Application No: AB/126/20/HH
Site Address: 38 Dalloway Road Arundel BN18 9HW
Description of works: Two storey rear extension, replacement windows, replacement cladding, infill to side void & installation of a fence.

Thank you for your internet representation made on 11th December 2020 which has been recorded as an objection with the comments as follows:

BLOCK PLAN
[proposed]

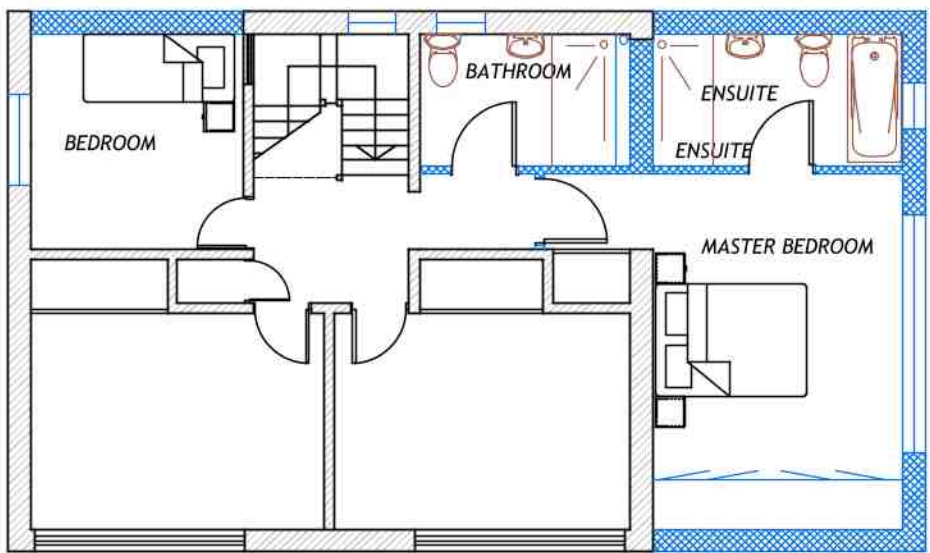
Comments - The following are comments that I wish to raise for consideration by the planning committee regarding the proposed planning application, regarding the fencing in of the whole front garden with a 1.8m solid boarded fence:

- The Deeds of the properties in this area state that the front gardens be maintained as open planned.
- An application to install a much lesser intrusive hedge in a near-by property was turned down in the recent past.
- The example fence shown within the photographs is the last house in Dalloway Road and is encapsulated within a cul-de-sac and not on the main road, also it has a trellis top, not a solid 1.8m close boarded fence.
- The positioning of the proposed fence butting up to the pavement poses a dangerous blind spot for cars driving off the adjacent property (no. 36), where the pavement is frequented by families, children running & cycling.
- Personally I consider enclosing the front of this property (no. 38) with a 1.8m solid boarded fence will be extremely detrimental to the overall appearance of the area, as well as violating the Deed's covenant.
